CITY OF ALBUQUERQUE

December 8, 2016

**Re: AAA Roofing Storage space
2509 Comanche RD NE
Traffic Circulation Layout
Architect's Stamp 11-09-16 (G16-D004)**

SITE PLAN / TRAFFIC CIRCULATION LAYOUT SCALE: 1/16" = 1' - 0"

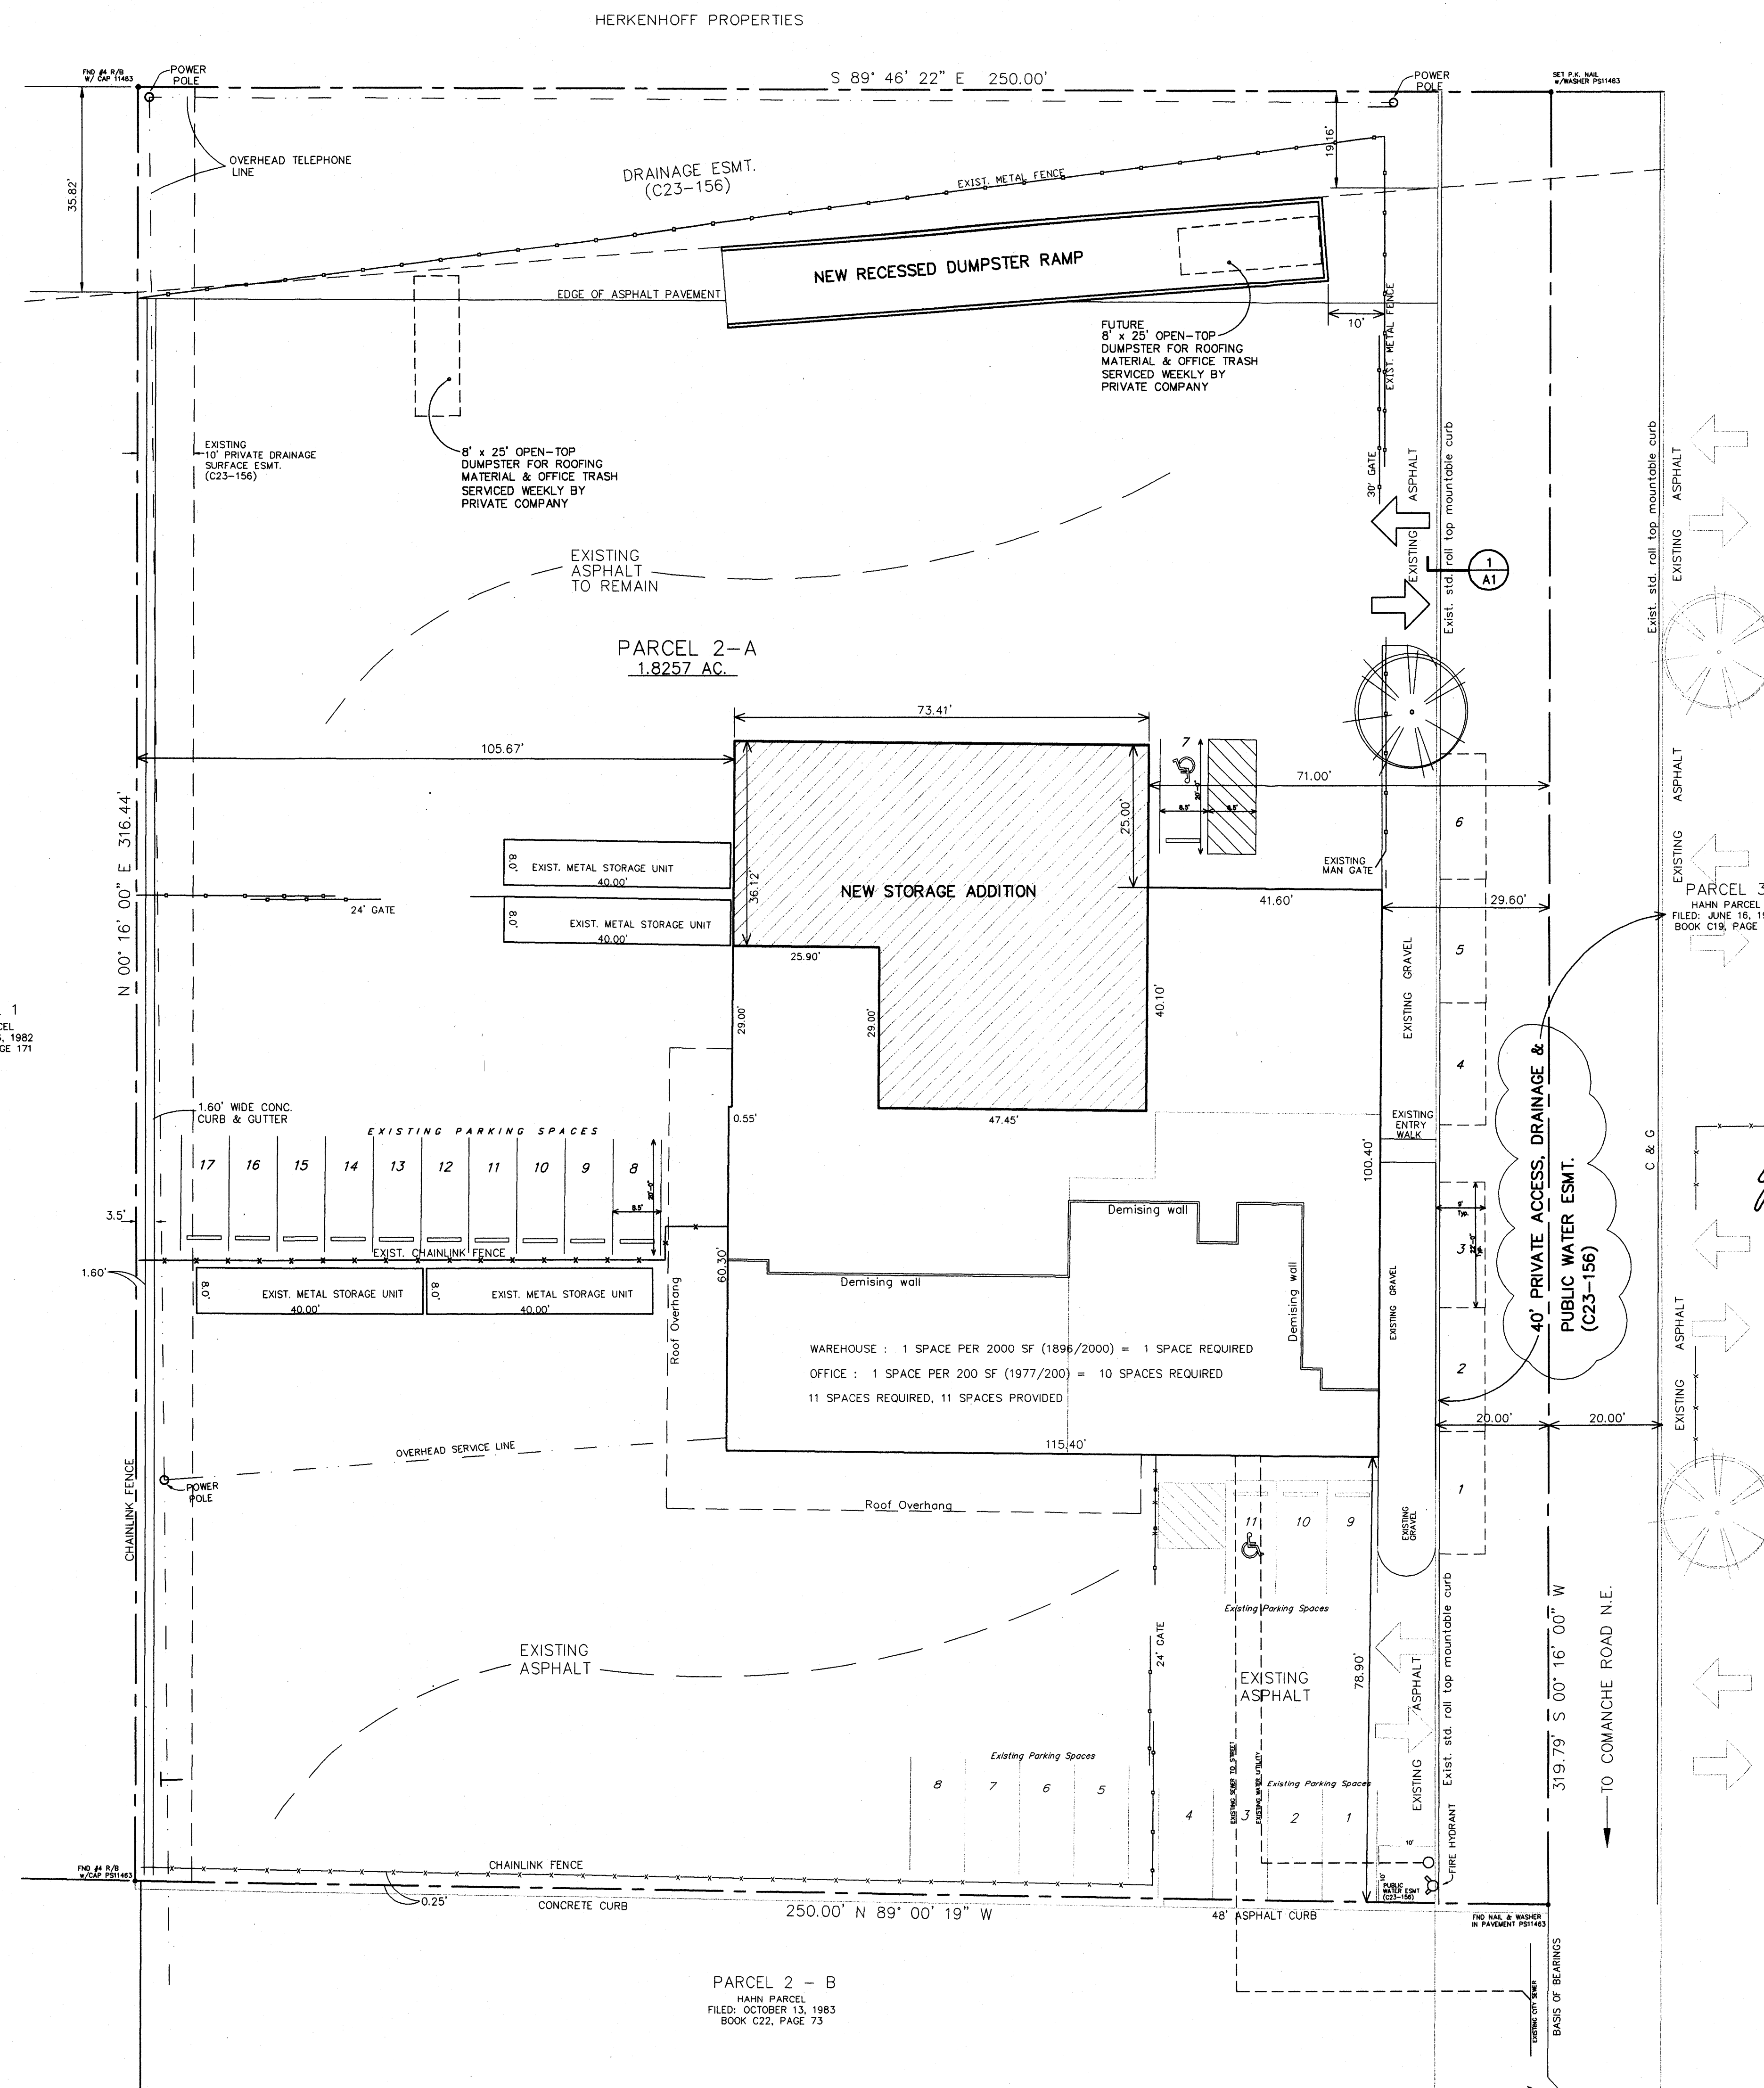
1. Please identify all accessible building entrances, drive entrance widths and anything that influences the parking and circulation on the site.
2. Please list the width and length for all existing and proposed parking spaces. Some dimensions are not shown. Indicate if existing parking will be restriped. Will the existing handicap parking remain? If so, it should be updated.

3. The ADA accessible parking sign must have the required language per 66-7-352.4C NMSA 1978 **"Violators Are Subject to a Fine and/or Towing."** Please call out detail and location of HC signs.

4. The ADA access aisles shall have the words **"NO PARKING"** in capital letters, each of which shall be at least one foot high and at least two inches wide, placed at the rear of the parking space so as to be close to where an adjacent vehicle's rear tire would be placed. (66-1-4.1.B NMSA 1978)

5. Per DPM, a 6 ft. wide ADA accessible pedestrian pathway is required from the HC parking stall access aisles to the building entrances. Please clearly show this pathway and provide details.
